Department of Transportation

September 19, 2022

SH 115A
El Paso County

RE: State Highway 115 Orton Borrow Pit and Steer Batch Plant_CDR-2211

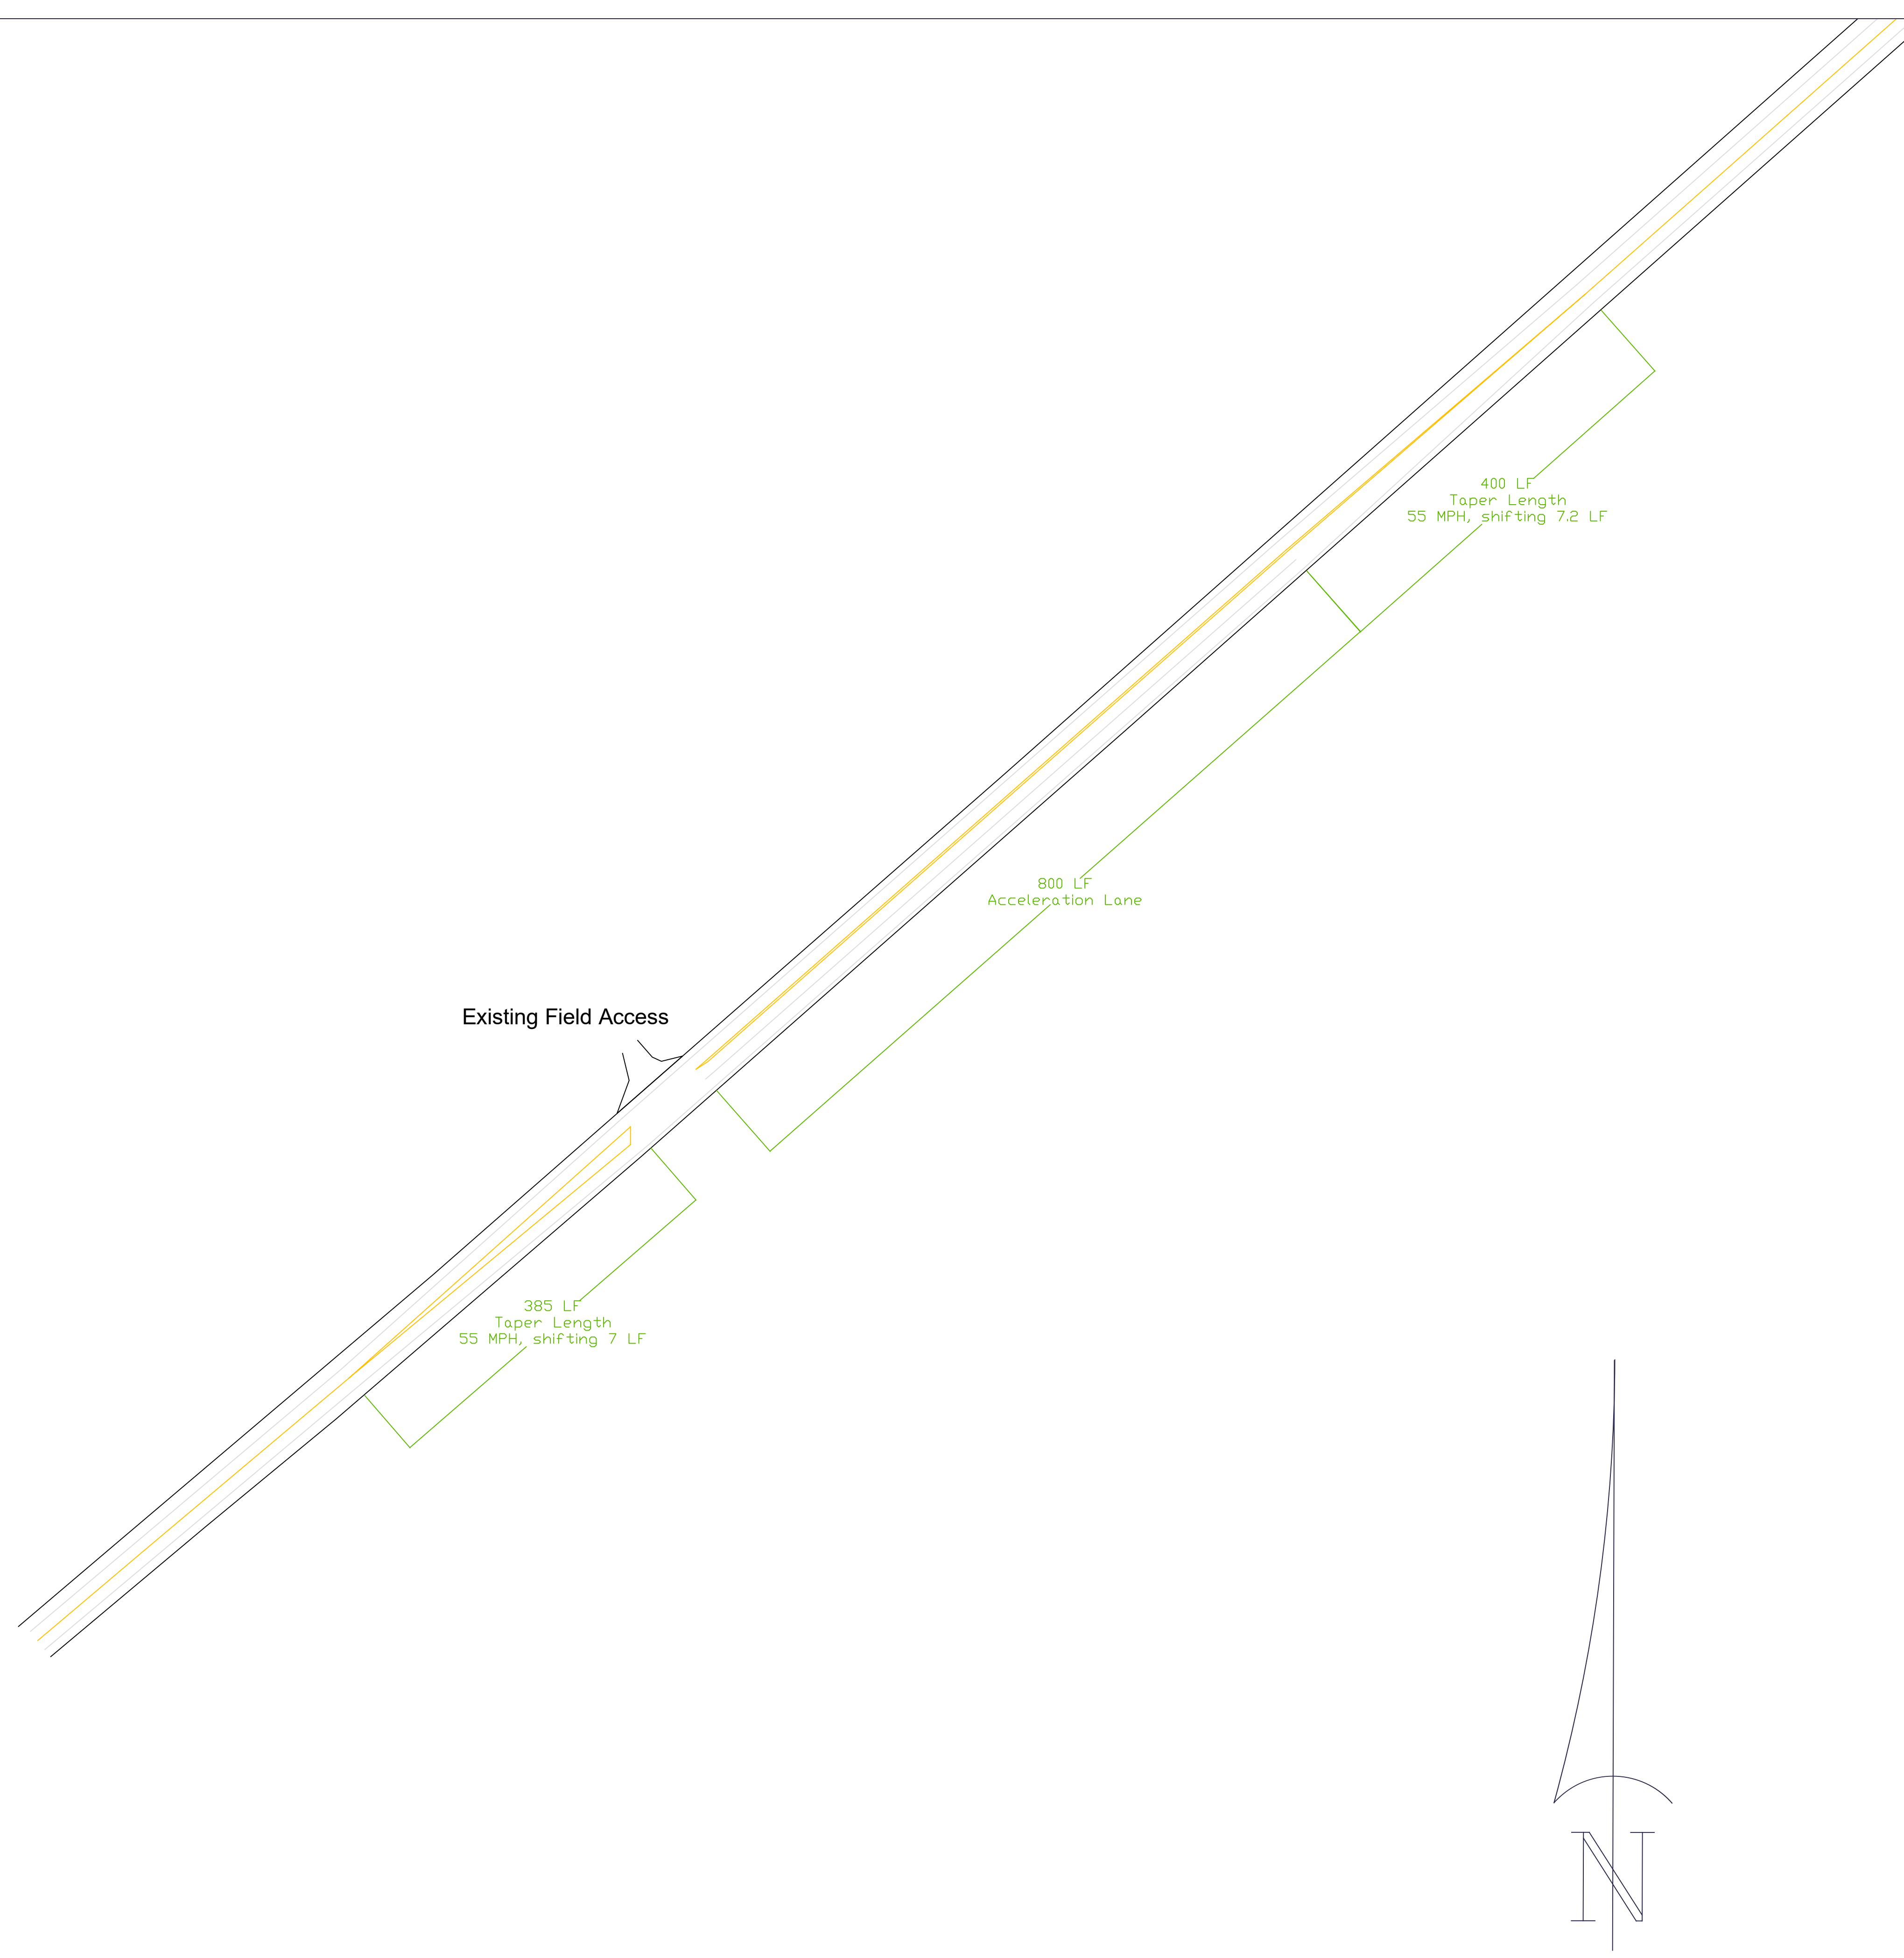
- **It is assumed, based on the haul route described, that no left turns into the access will be necessary; therefore, left turns (NB) into the access should be prohibited unless a NB left turn deceleration lane is constructed per the SHAC.** Otherwise, a design waiver could be granted.

- **It is assumed, based on the haul route described, that no right turns out of the access will be necessary; therefore, right turns (SB) out of the access should be prohibited unless a SB right turn acceleration lane is constructed per the SHAC.** Unless a design waiver is approved.

- **A right turn lane for SB trucks with deceleration and taper lengths is required since the access has a projected peak hour right turn ingress turning volume greater than 10 vph - 25:1 taper + 700 ft.**

- **A left turn acceleration lane for NB trucks is required and called for in the TIS; however, what is called for in the TIS does not meet the SHAC criteria. The lane must meet the design criteria specified - 1170 ft + 25:1 taper. Unless a design waiver is approved.**

- **The sight distance of 900 ft given in the TIS is shorter than the required 1020 ft.**
- **All speed lane changes must meet all SHAC design criteria including lane width and grade adjustment factors.**
